## Application for a Non-Material Amendment Following a Grant of Planning Permission

Internal alterations, demolition of rear sun room and replacement with new sun room. Conversion of existing barn to studio/home office and re-cladding with timber cladding. Replacement of existing timber sash windows with double glazed sash windows.

22/01384/FUL

Revised elevations to proposed replacement sun room.

South Elevation

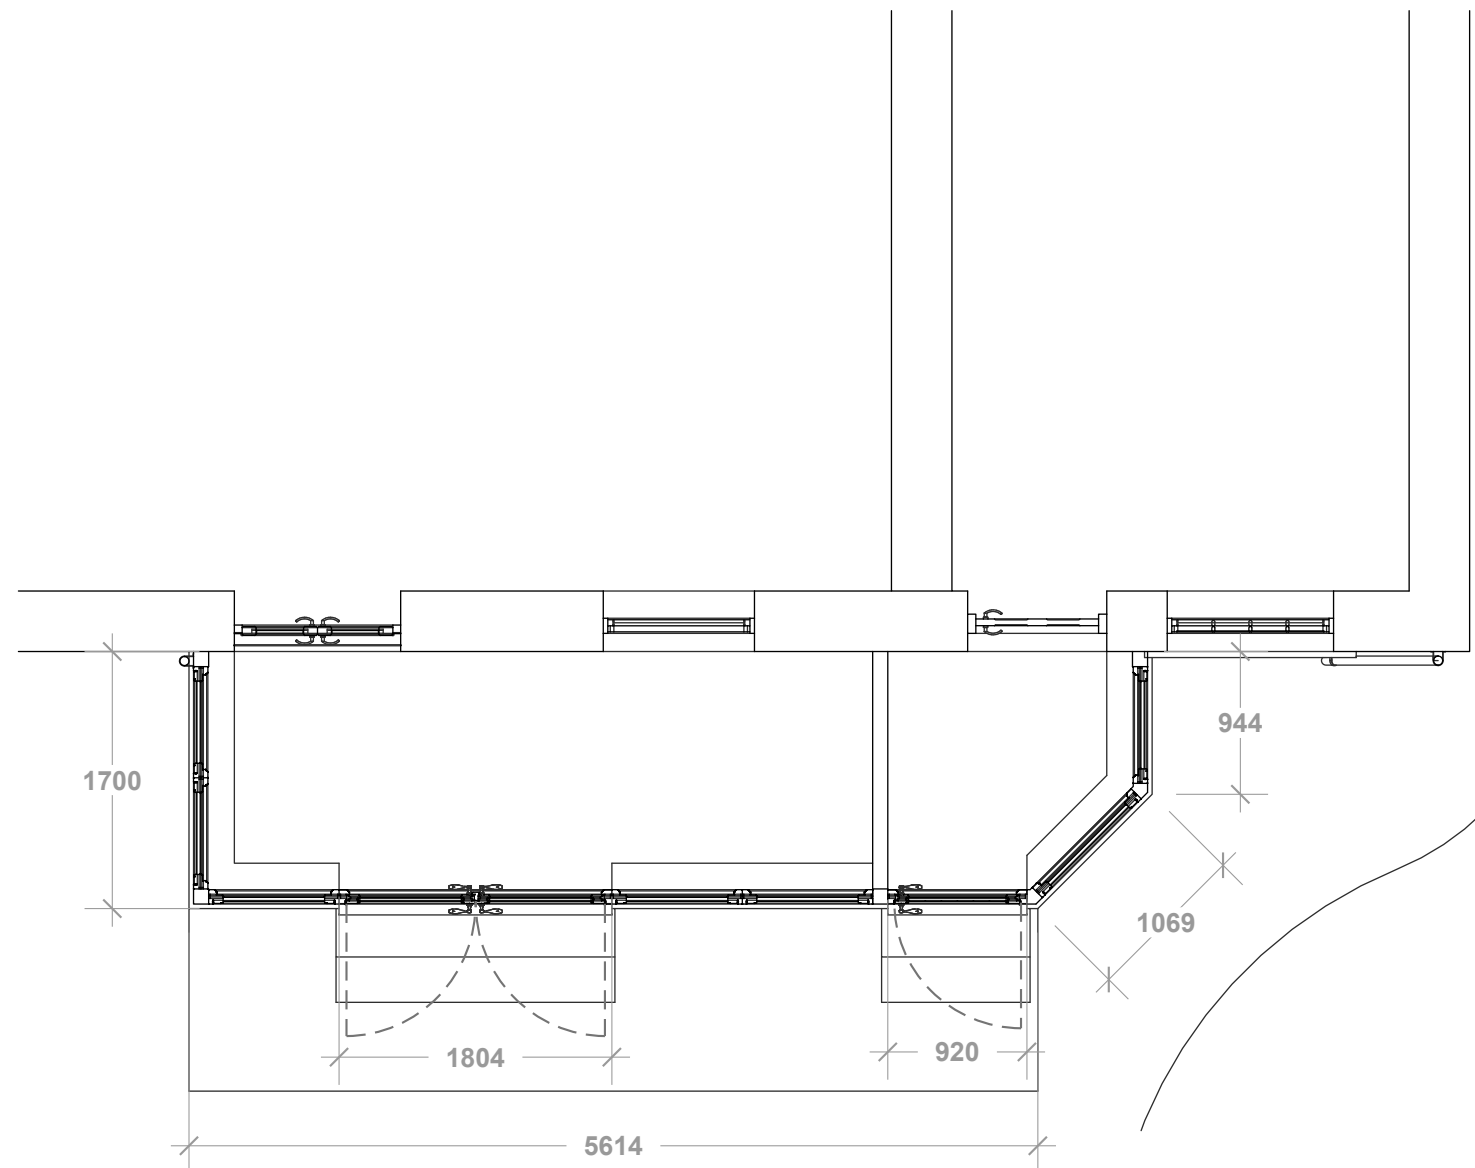
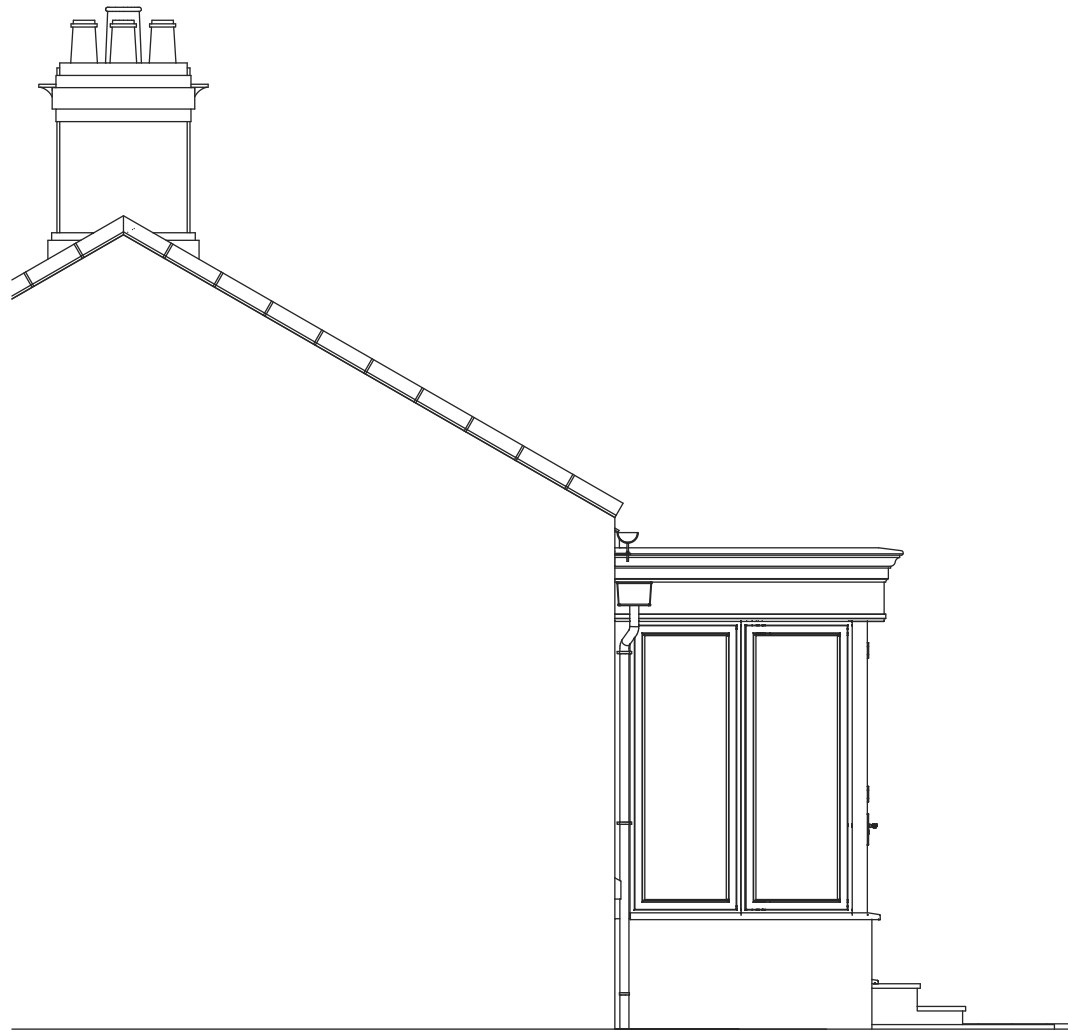
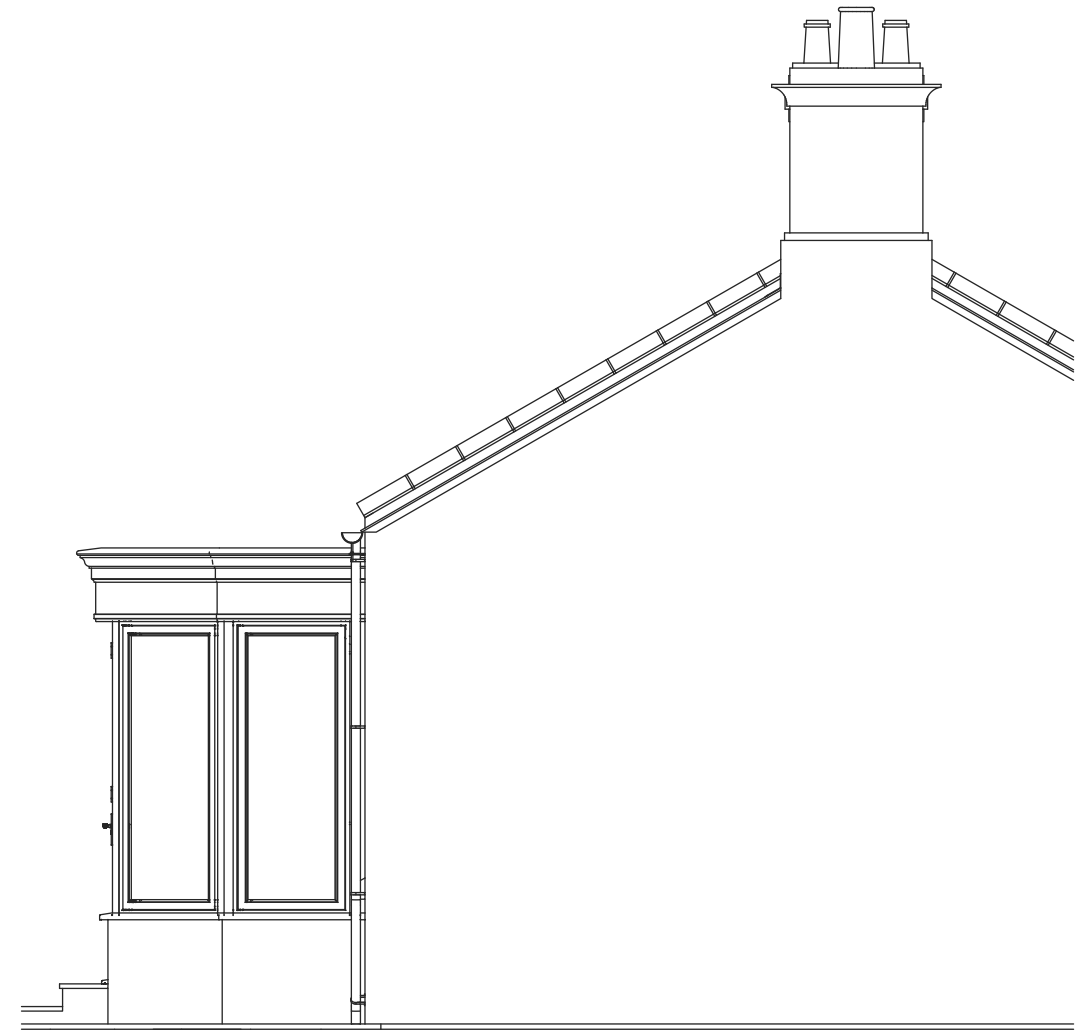
Revised scheme drawings produced by conservatory manufacturer.
